Application for a non-material amendment following a grant of planning permission.
Town and Country Planning Act 1990

NEW BUILDS PLOT 1 HOUSE & PLOT 2 BUNGALOW

DEMO OF HOUSE & ERECTION OF 2 NO. DWELLINGS (RE-SUBMISSION FOLLOWING EP/15/15/PL)

Plot 2: Ground Floor Plan

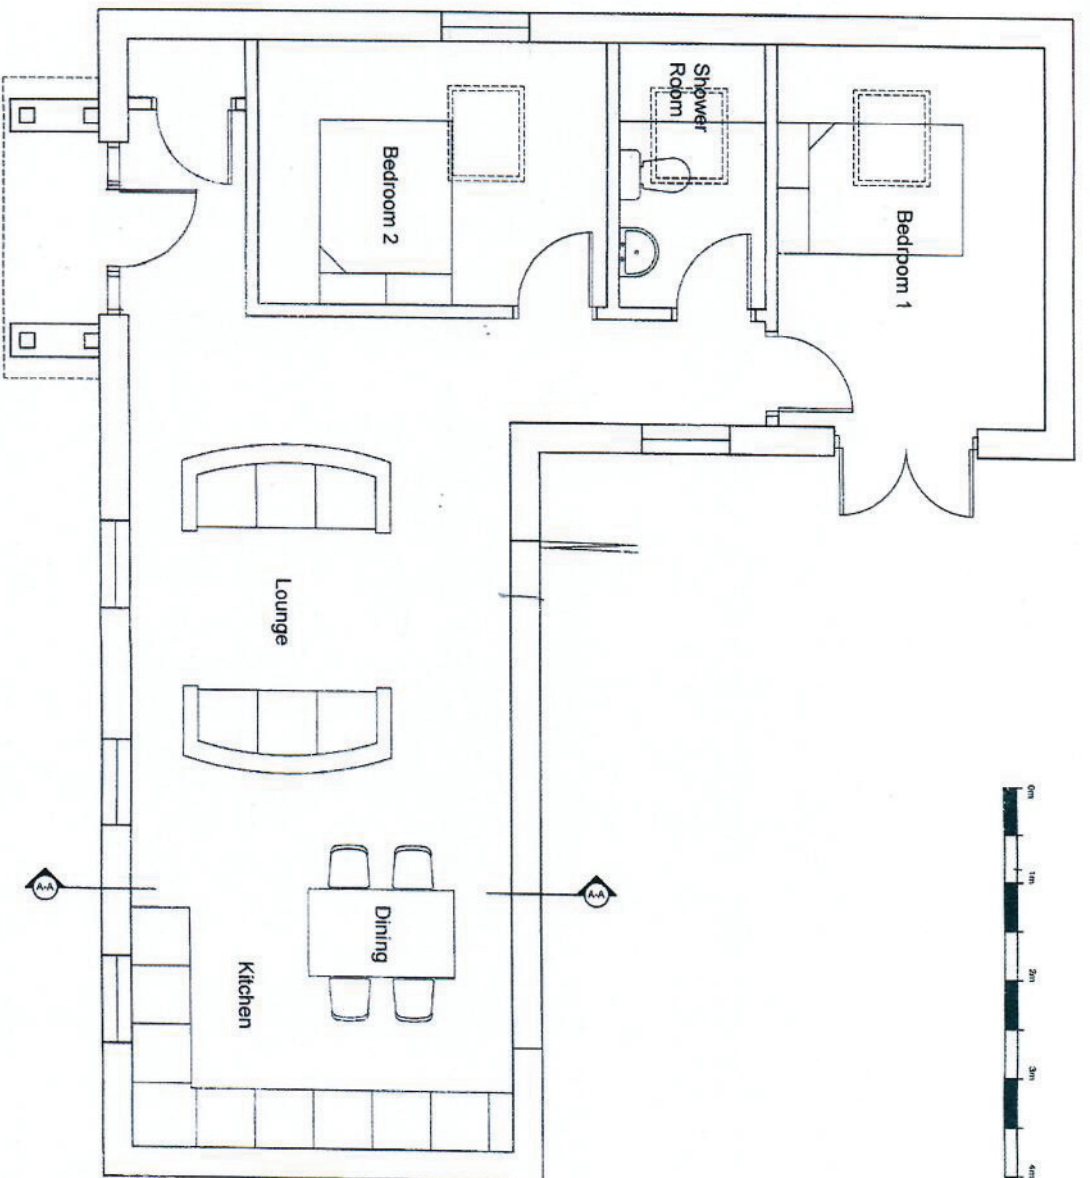
PLOT 1 HOUSE - REPOSITION WC
PLOT 2 BUNGALOW - DOUBLE FRONT DOORS TO SINGLE DOOR & GLASS SIDELIGHTS
PLOT 2 BUNGALOW - BED 2 WINDOW TO MATCH ALL OTHER WINDOWS, IN STYLE, HEIGHT AND LOOK, INCLUDING BRICK COINS.

PLOT 1 - RECONFIGURE WC TO MAKE BETTER USE OF LIVEABLE AREA
PLOT 2 - TO BRING IN MORE LIGHT, MAKE THE FRONT ENTRANCE COMPLY WITH PART Q B.R
PLOT 2 - TO KEEP ALL WINDOWS THE SAME IN STYLE, LOOK AND COMPLY WITH B.R FIRE ESCAPE WINDOW IS TOO HIGH OFF THE FLOOR LEVEL.
